**EL PASO COUNTY PLANNING AND
 COMMUNITY DEVELOPMENT
 DEPARTMENT**

STORMWATER MANAGEMENT PLAN CHECKLIST

Add text:
 EPC Filing No.: PUDSP222

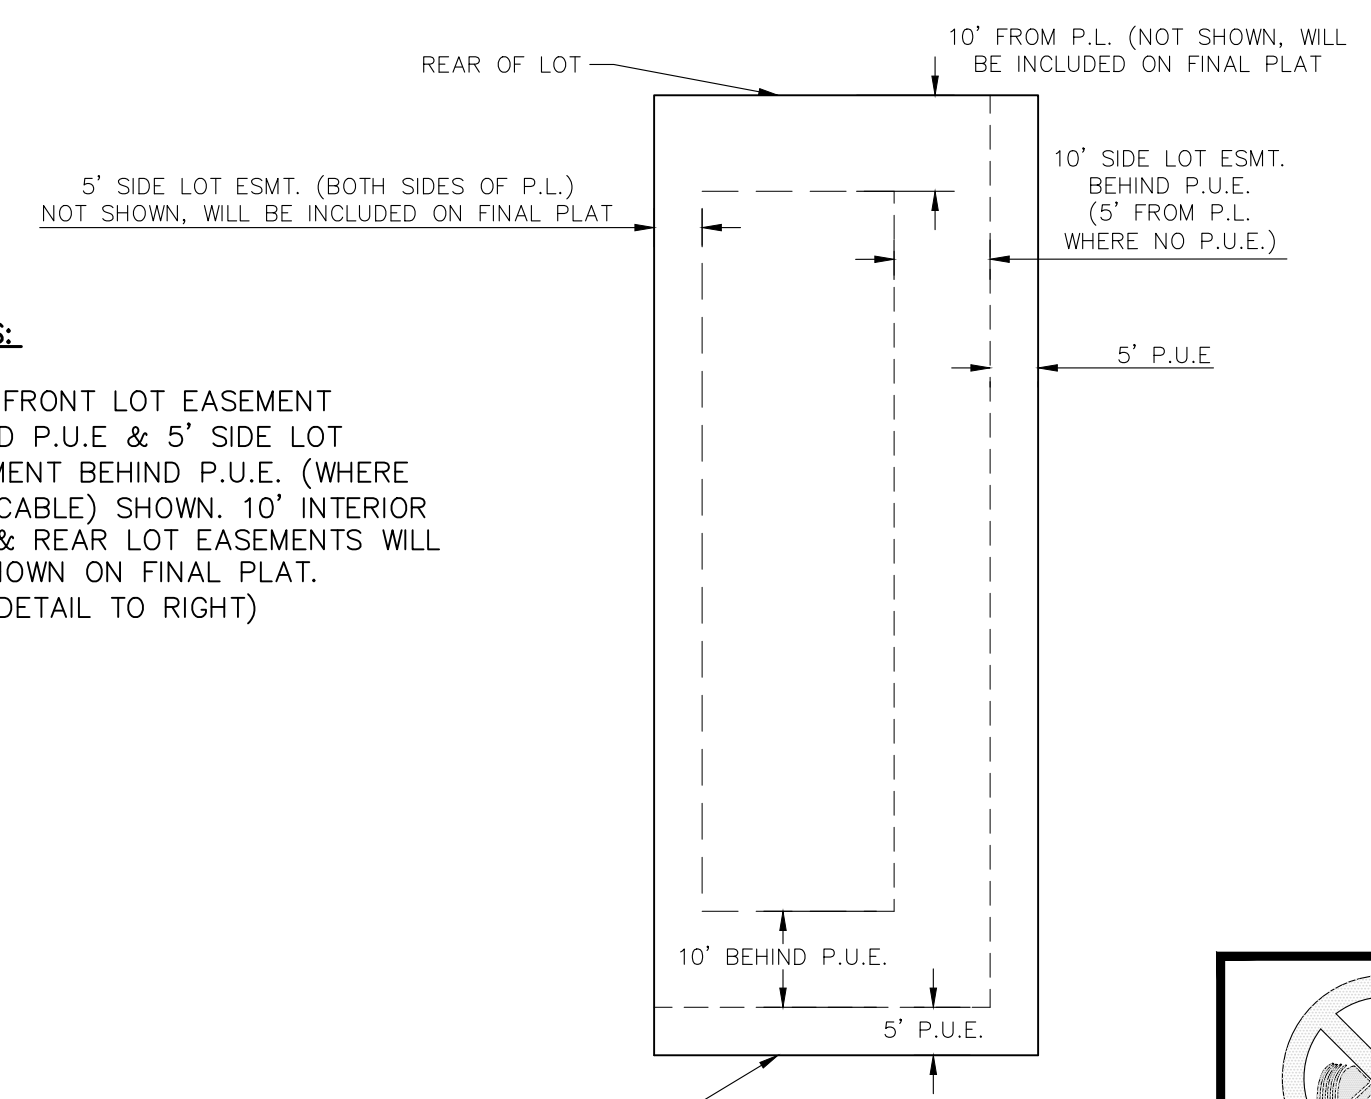
| Revised: July 2019 | | Applicant | PCD |
|---|--|-----------|-----|
| 17a | construction site boundaries | ✓ | N |
